Planning
Planning Correspondence “Ref proposed 50 vehicle access from Summer Lane”
Redaction Please

From: Simon Davis
Sent: 20 April 2026 12:06
To: 'James Smith' [Redacted]
Cc: Darren Schofield [Redacted] Cleo Jefferies [Redacted] Oliver Shaw [Redacted]
Subject: Pagham Phase 4b - App P/30/26/OUT

VEHICULAR ACCESS ACROSS SUMMER LANE

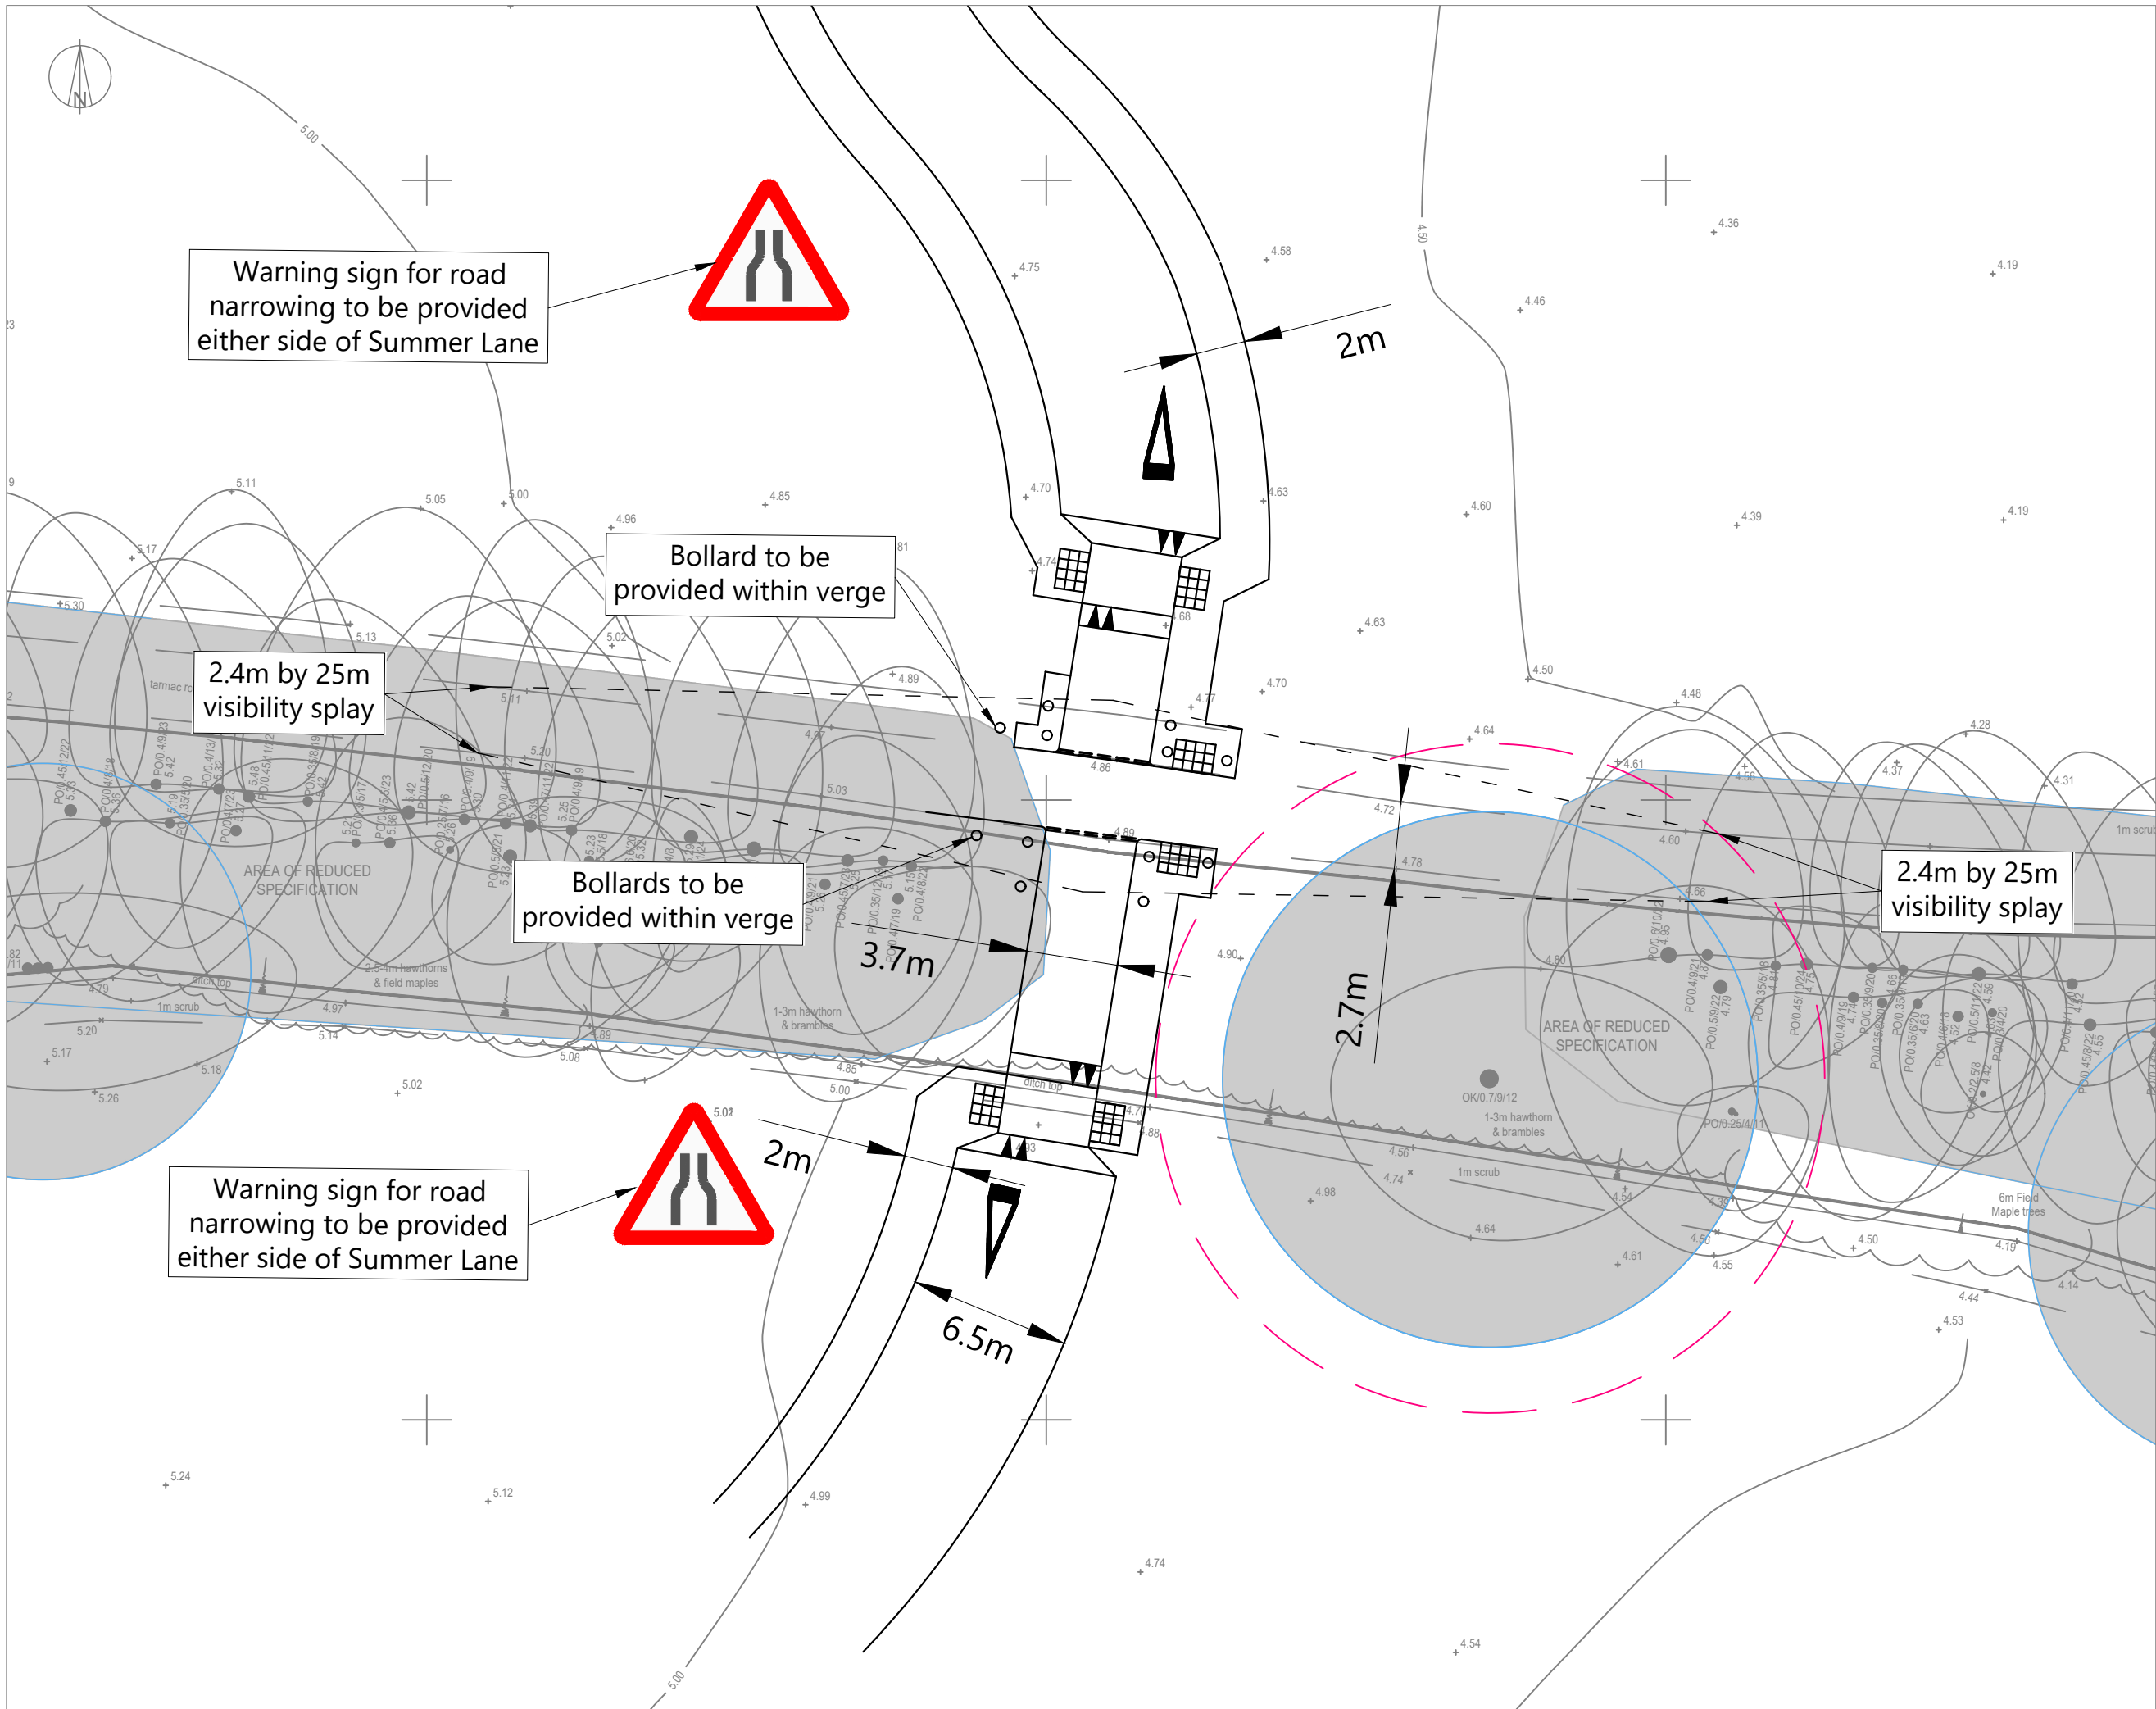
David Easton and I had a conversation last week about the vehicular access arrangements and collectively, we would prefer if the access arrangements for both applications were the same i.e. both from P/15/24/OUT to the south. Whilst I acknowledge that Highways raise no objection to the proposal under P/30/26/OUT for 50 dwellings to be accessed from Summer Lane (their comments are now online), our preference is for no extra vehicles on Summer Lane.

At the Meeting I raised the need for signage at the junction of Summer Lane and Pagham Road to make it clear thar there was no access to the new site from Summer Lane (i.e. for the P/31 application). However, this would need to be more complex for the P/30 proposal as some visitors would need to use Summer Lane and some would not be able to access the site that way. This will create unnecessary confusion. I acknowledge the justification given at the meeting for this different approach, but I wonder if the reason might actually be to make the 130 scheme more palatable than the 120 one, from a vehicle access point of view.

Can you give this matter some further consideration.
